Planning Application Ref: BR/163/18/T

Location: Nyewood Infant And Junior School, Brent Road, Bognor Regis

Description of works: Fell 1 No. elm tree to 1m; reduce upper crown on north aspect by up to 2m, thin crown by 20% & lift southern canopy aspect to 4m to 1 No. ash tree, reduce crown of 1 No. hawthorn tree by 2-3m & reduce crown of 1 No. hawthorn tree by 3-4m.

Nyewood Infants School Map1

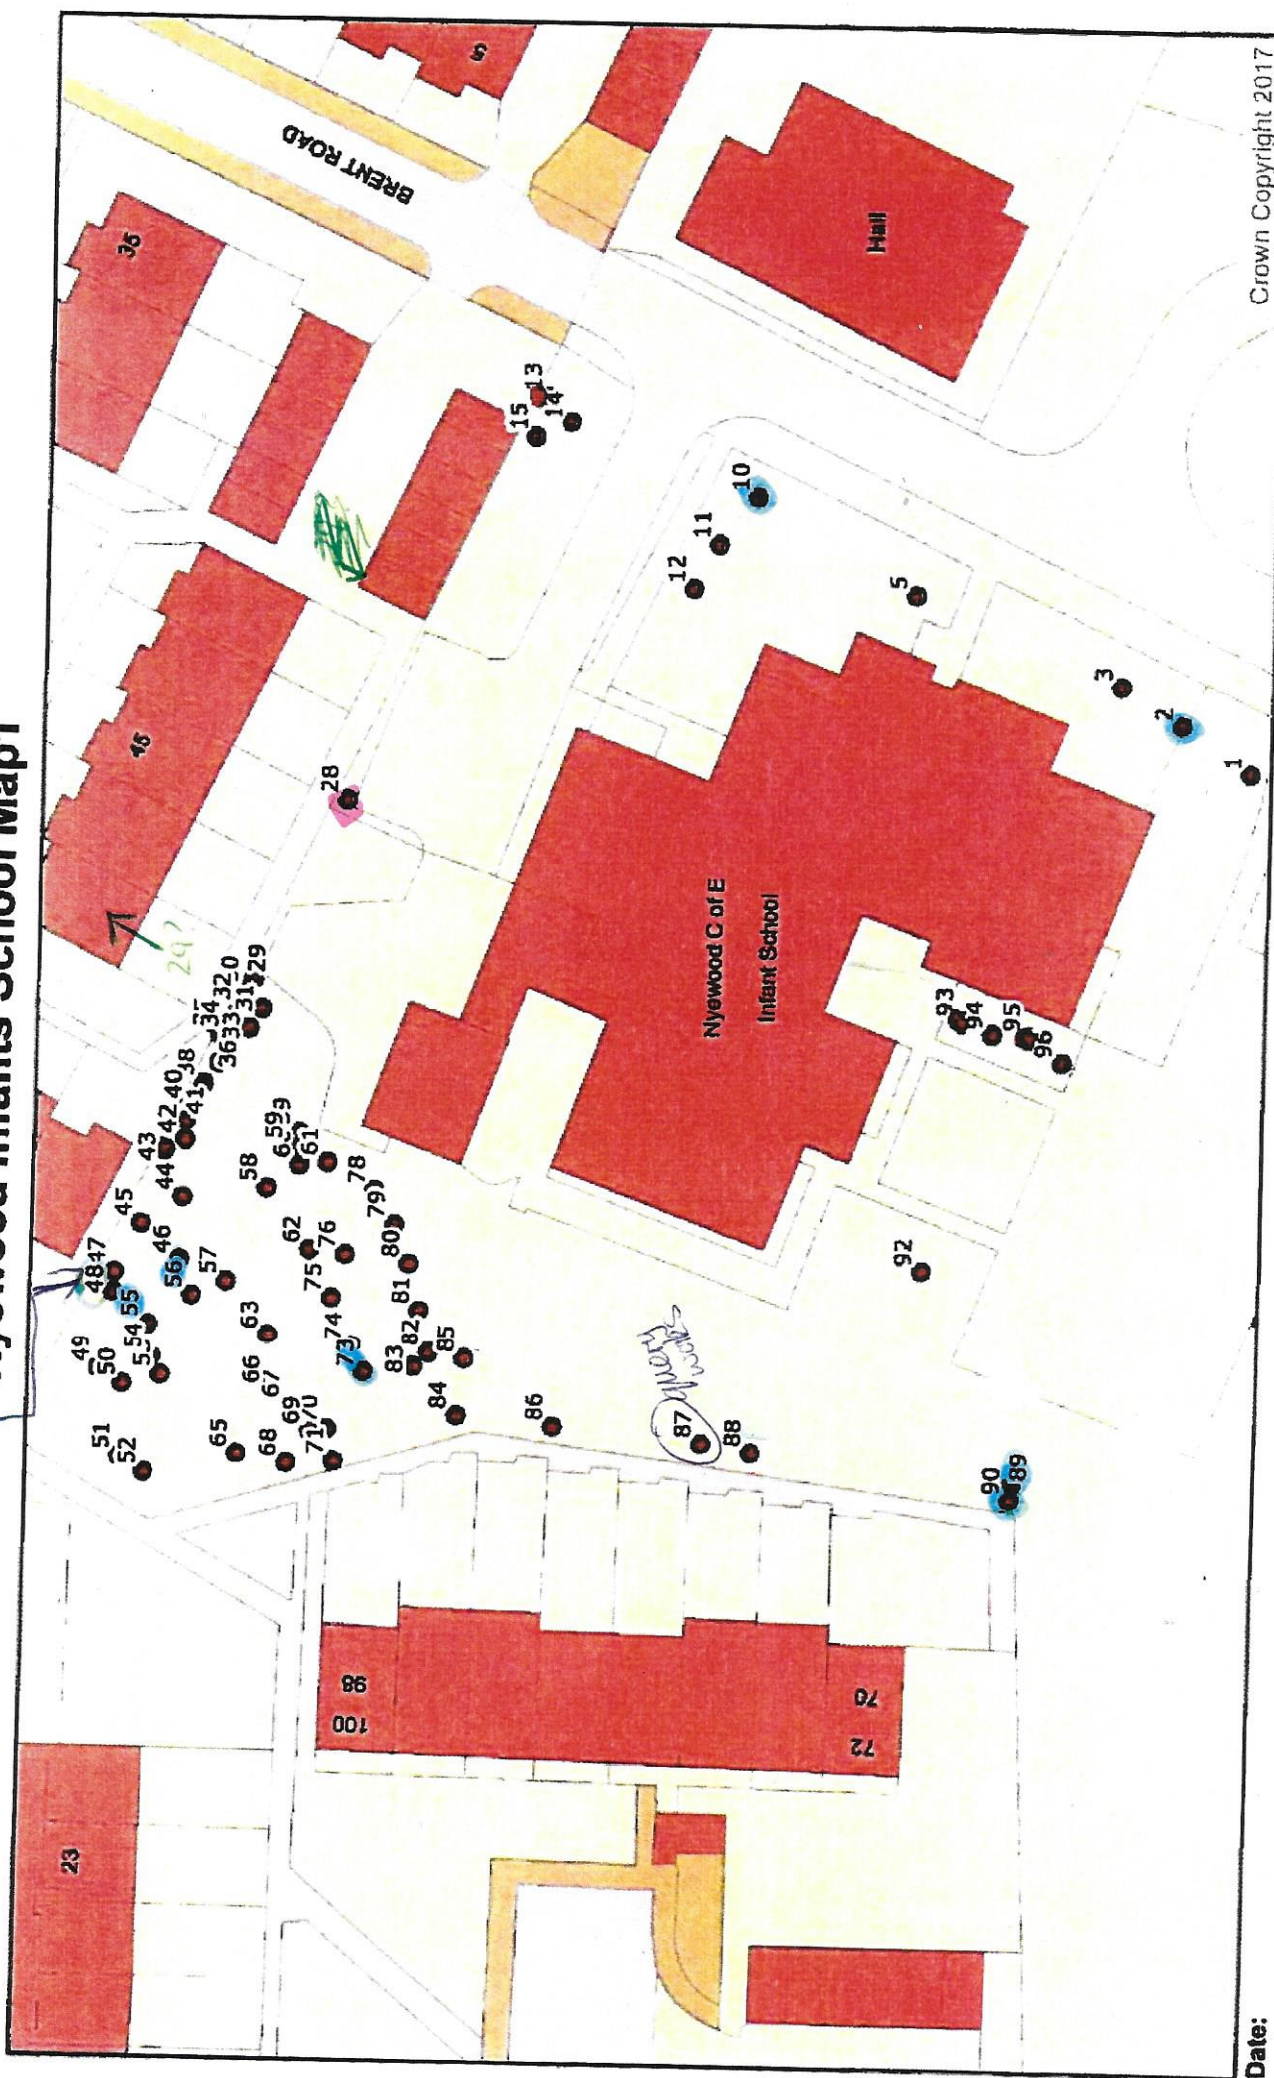
- T28 on the submitted plan is a hawthorn. The ash shown in the submitted photograph (and which I have considered as being the tree intended for pruning work) is growing among the cluster of trees T29-T35.
- There are three Tree Preservation Orders in effect on this site (Bognor No2, TPO/BR/1/02, TPO/AW/11/10). Having assessed each of these trees I conclude that none are associated with any Order and consent from the Local Planning Authority is not required to undertake the works described, at this time.

- I recommend we advise the applicant they can proceed with the works as described, without further recourse to this authority.
